**WEST SUSSEX COUNTY COUNCIL  
PRE APPLICATION CONSULTATION**

**SUBJECT: EG/57/16/PL**

**DESCRIPTION: Medical centre with pharmacy retail unit & other ancillary uses together with access onto Barnham Road & associated car parking. This application is a Departure from the Development Plan. – Revised Highways Informaiton**

**SITE: Land adjacent to the Croft Practice, Barhnam Road, Eastergate, PO20 3RP**

Drawing Number	Rev
2016-2889-AT-101

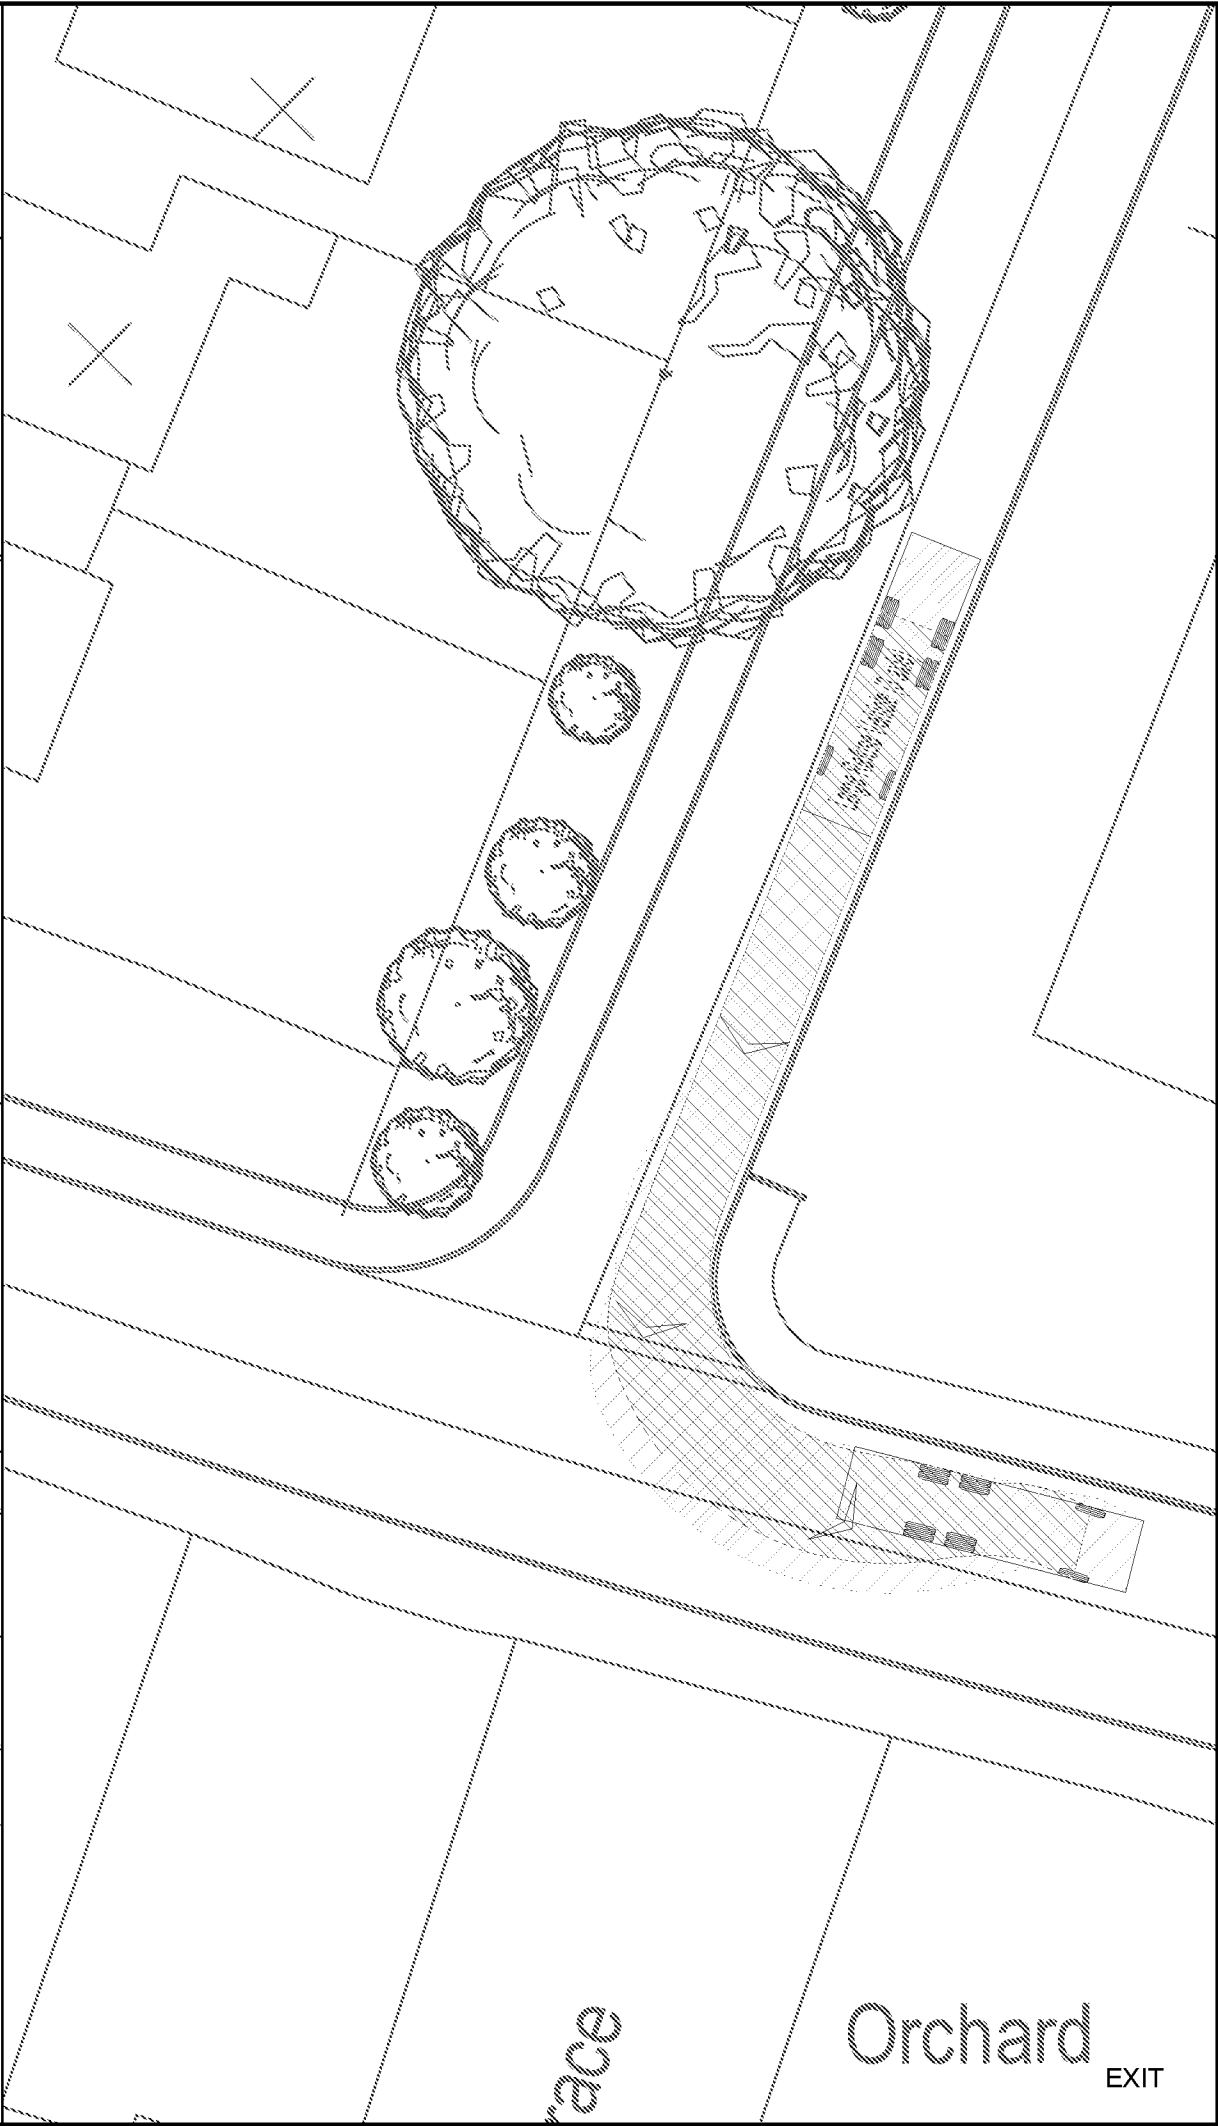
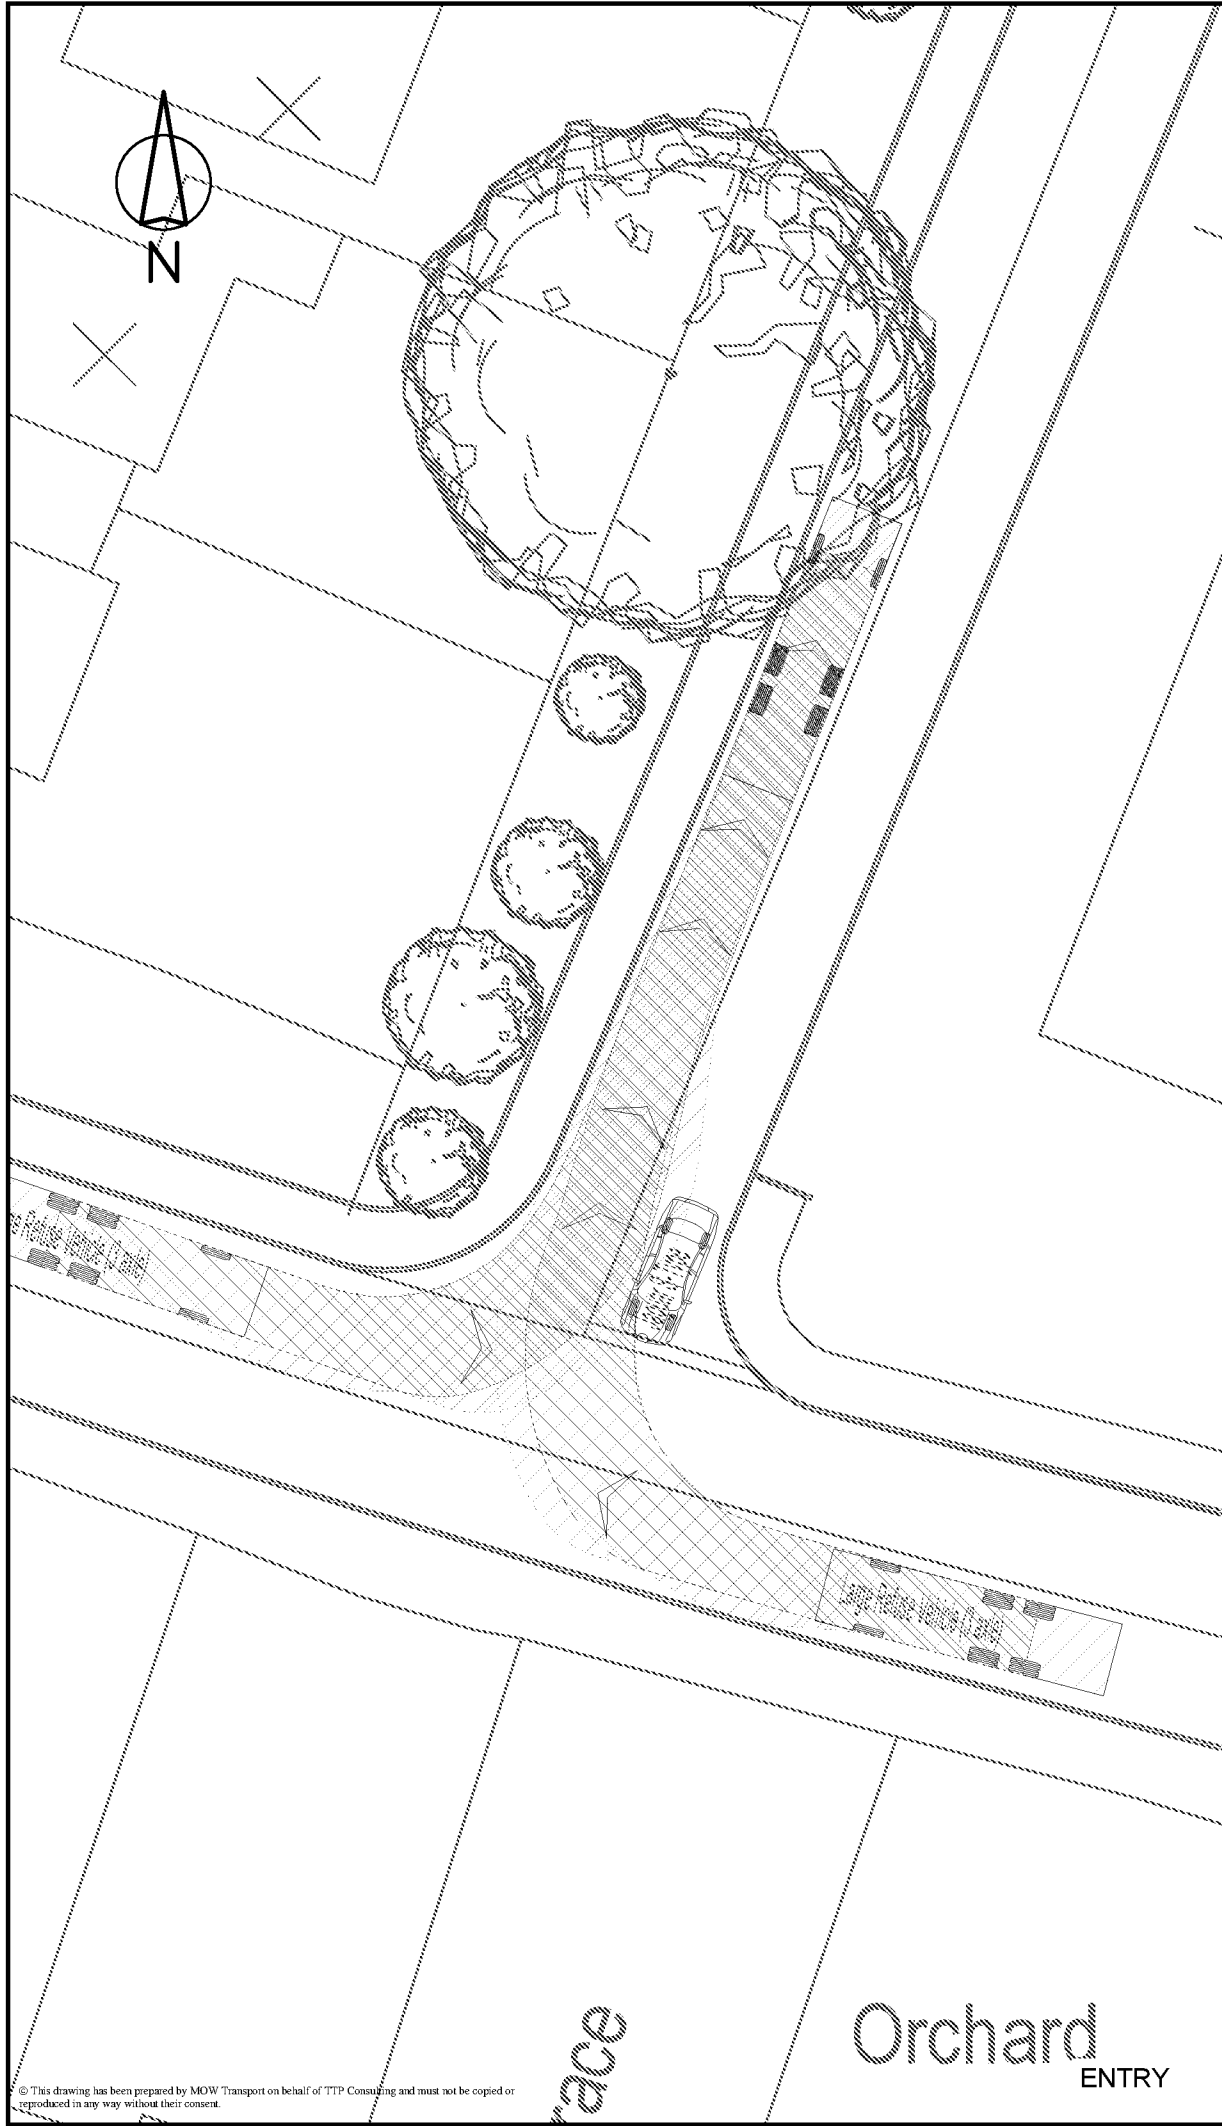
Drawing 2016-2889-AT-101 shows a large refuse vehicle entering and exiting the site. When exiting there is some overhang over the centreline of Barnham Road, this is the largest vehicle expected to visit the site and infrequently, given the nature and width of Barnham Road it is not unusual for this to occur. The tracking of the refuse vehicle entering the site from both directions also enters onto the opposing side of the access road slightly. Given the infrequent use of this access by such a vehicle the LHA would raise no concern to this. The RSA also raised no concerns to the access or tracking.
